Application number: 2026/91628	
What is the application for?:	Erection of 17 dwellings (Use Class C3) together with associated development inc
Address of the site or building:	land off, Boshaw View, Hade Edge, Holmfirth, HD9 2TZ
Postcode:	BD19 5LQ

Type of comment: An objection	
Do you wish your comments to be published on the website anonymously?	No
I Object in General to Jones Homes even thinking of starting a new site when their previous one is not finished. There is still flooding of Ground water on Snittlegate and into the football field that still has not been sorted. The promise of landscaping has never been done. Now for the objections to the new Greave Road site. 1 Highways a. The new access road is too near to the Dunford Road/Greave road junction. Many wagons use Greave road including the quarry ones to turn into Pennistone Road as they cannot manage the turn at the bottom of Dunford road by the Bowshaw Trout Pub. Cars also use this road as the traffic calming is easier to straddle. b. We have no proper bus service that can be used for trips to Holmfirth. The number 25a has recently been withdrawn. So every house built is going to have at least 2 cars to get to work and

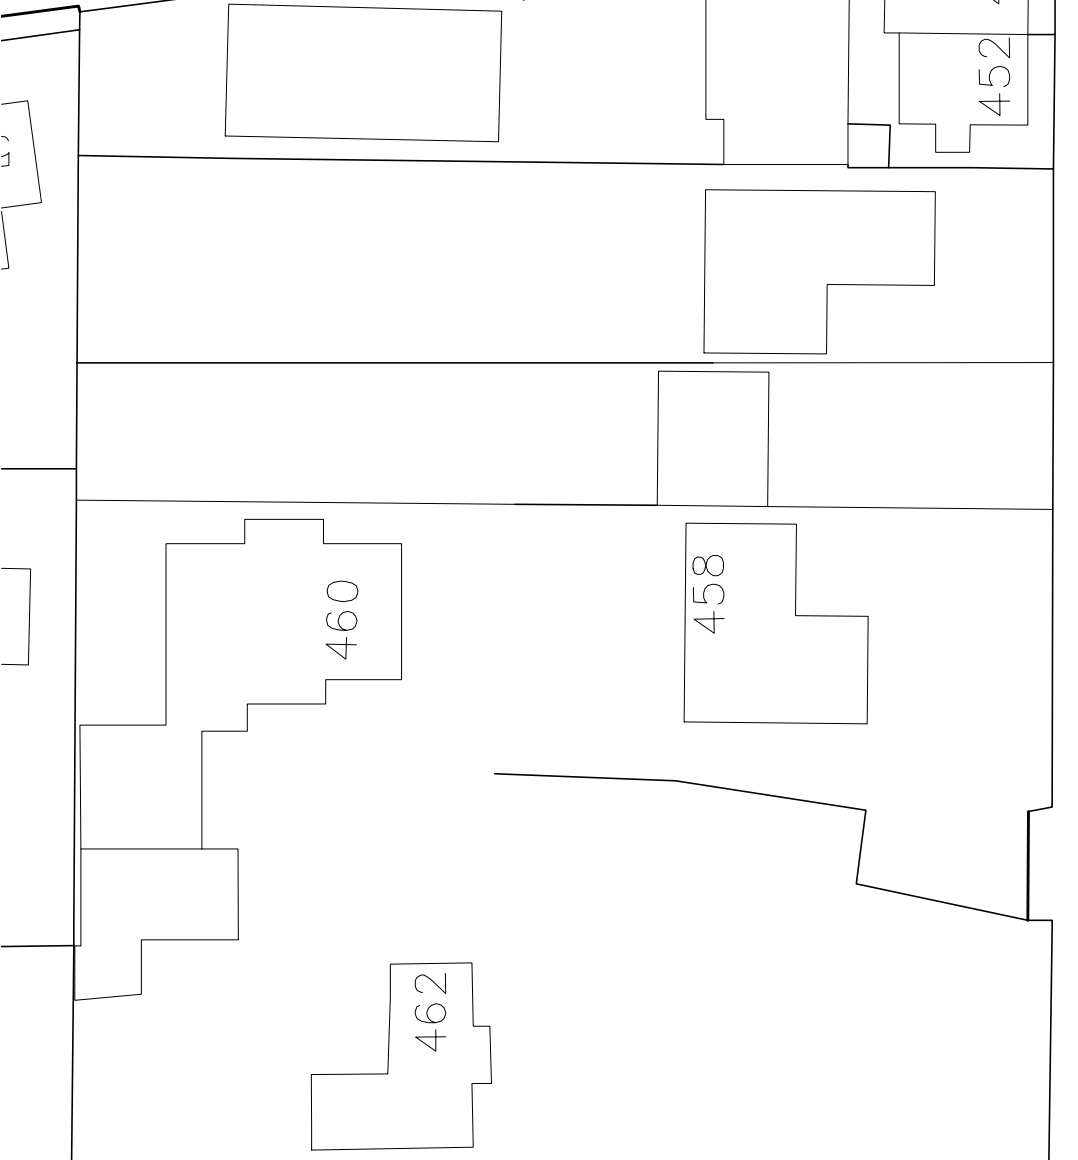
Looking at the positioning of the houses and Garages, I feel Jones Homes are being particularly vindictive towards the existing houses on the west side of the site. Particularly the siting of the garage so close to the house on the South West corner. surely it would be better to make the block of 3 small houses with foot access onto Dunford Road into 4 and do away with the house and garage at that point. I Think that there are too many houses being crammed onto the site surely people want a little more space to call there own for gardens. Another problem will be when it snows because people will then park their cars on either Dunford road or Greave road where the snow ploughs plough. This then causes problems for the snow ploughs getting through.
